**App: WA/127/21/OUT**

**Proposal:** Outline planning application with all matters reserved, other than means of access, for the construction of up to 131 No dwellings (30% affordable homes) and amendment to boundary of garden land to serve adjoining property (resubmission following WA/68/20/OUT). This application affects the character & appearance of the Walberton Village Conservation Area & is a Departure from the Development Plan.

**Address:** Land west of Tye Lane Walberton

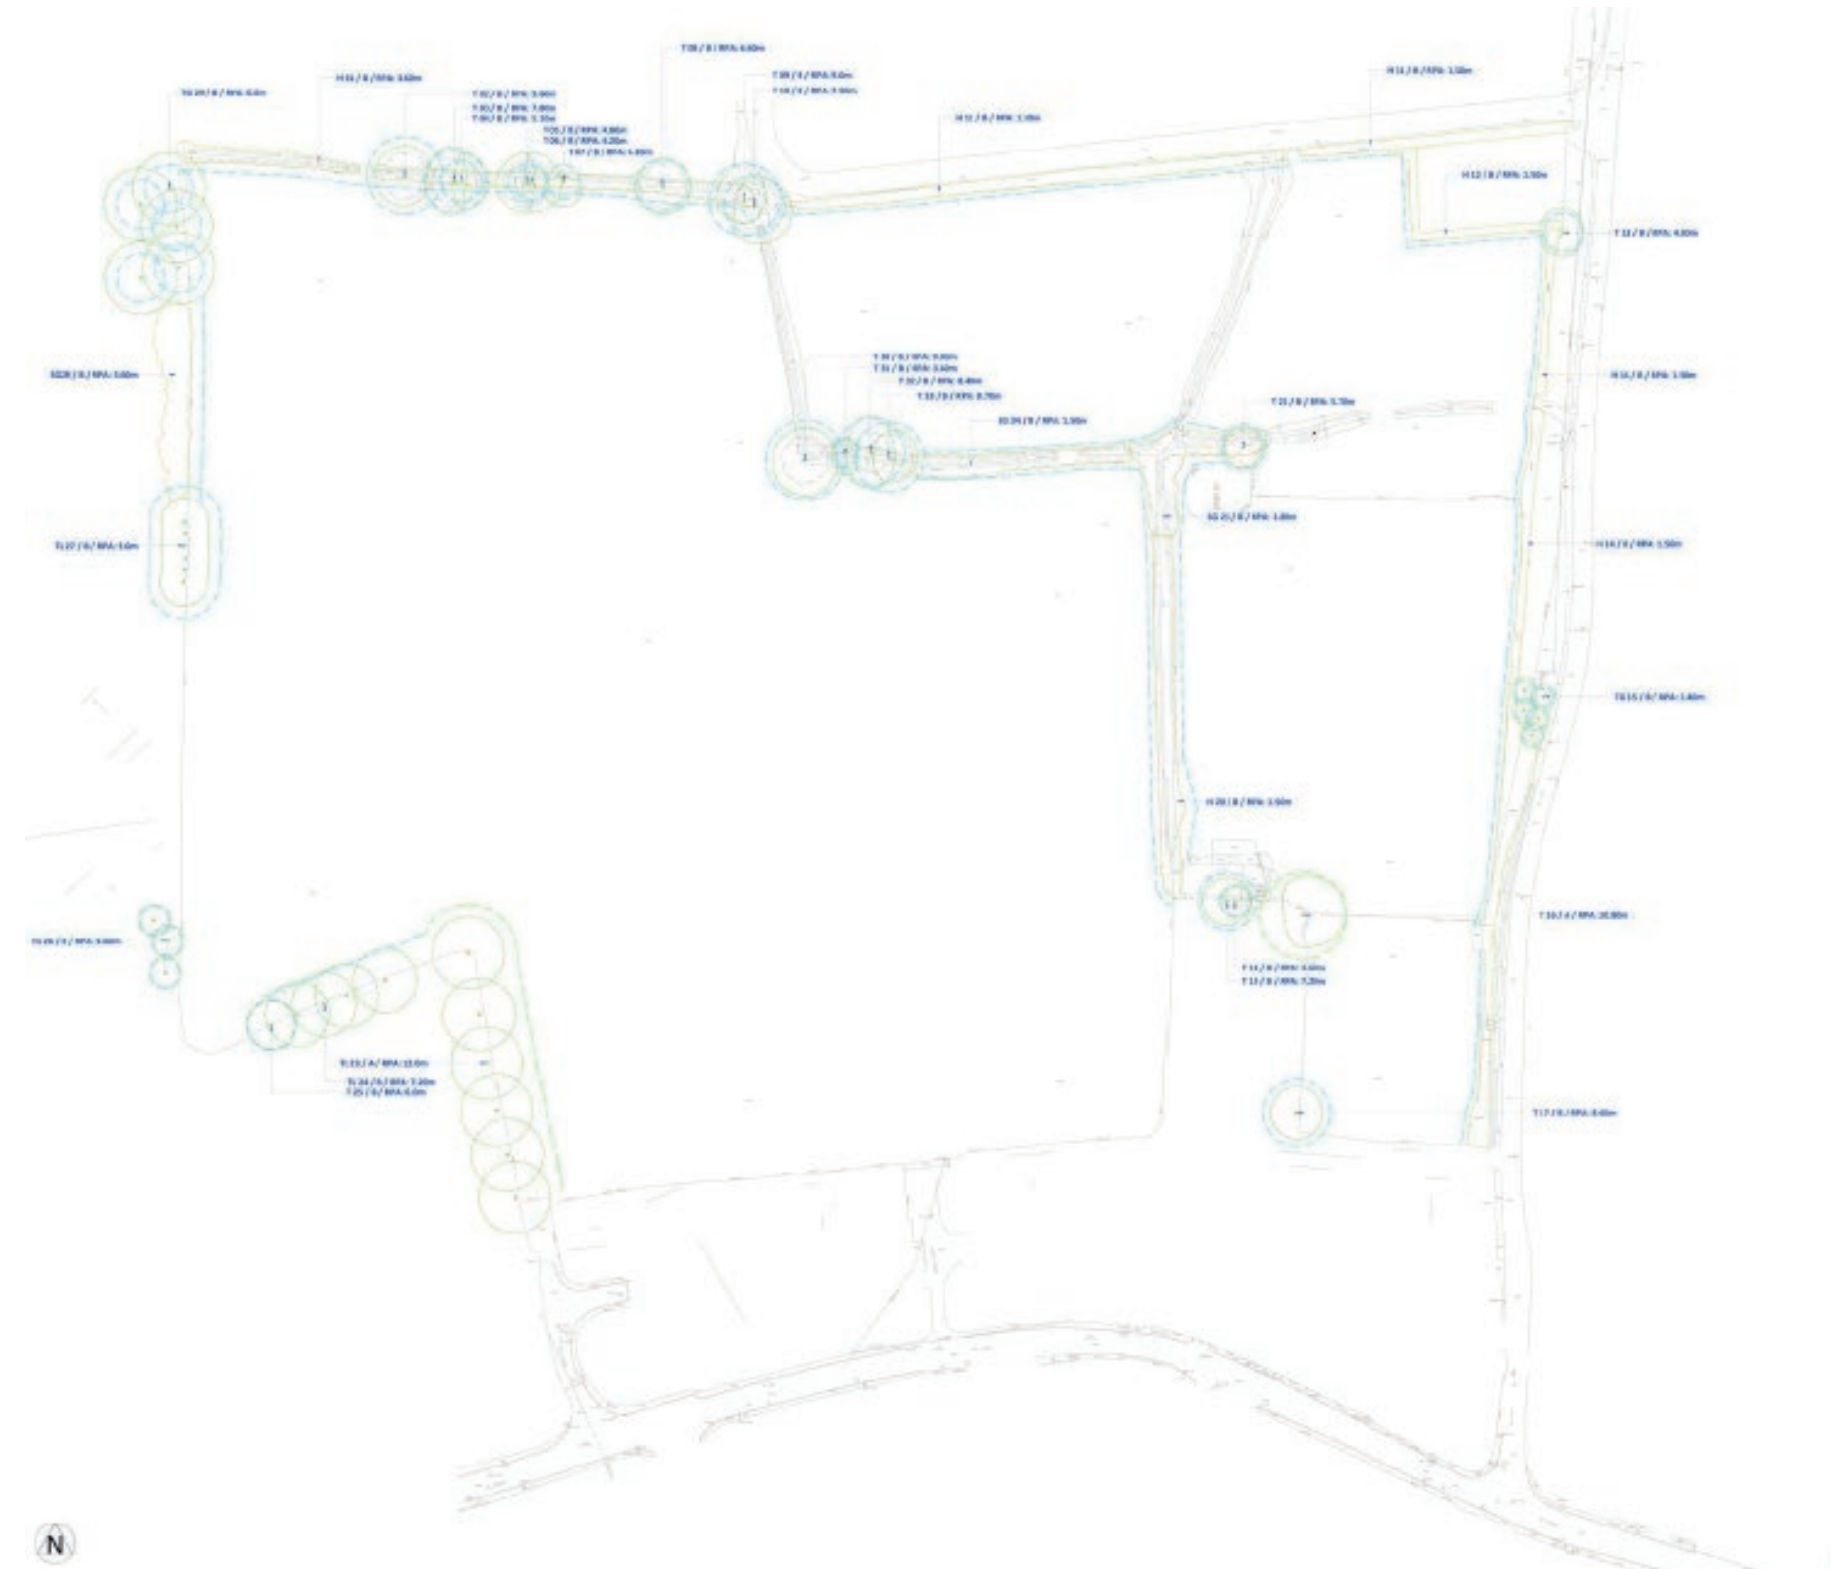
Whilst the number and size of the proposed dark corridors are a welcome addition to the bat mitigation scheme, we are concerned that a critical part of the foraging and commuting network has been missed. The static bat detector surveys identify that 'Location 1' (north-west margins of field 1) in the Phase II Ecological Survey report as having the highest levels of bat activity on the site, which includes light sensitive species such as barbastelles (Annexe II) and Myotis Sp. However, there is no dark corridor here.

The layout at this stage is only indicative and it might be that gardens are proposed to back on to this area and form the 'dark corridor'. However, it is our experience that once a development is occupied garden security and even Christmas lights are installed in an uncontrolled manner and so additional lighting levels must be considered as an inevitable consequence intrinsic to a development.

The landscaping and layout plans should be updated to include a dark corridor in the north west corner of 'Field 1' and submitted for our approval as part of this application. Fencing must be used to ensure gardens do not encroach the dark corridors.

The proposed habitat enhancements are suitable but should be updated to reflect improvements to bat and dormouse mitigation and shown on the landscaping plans.
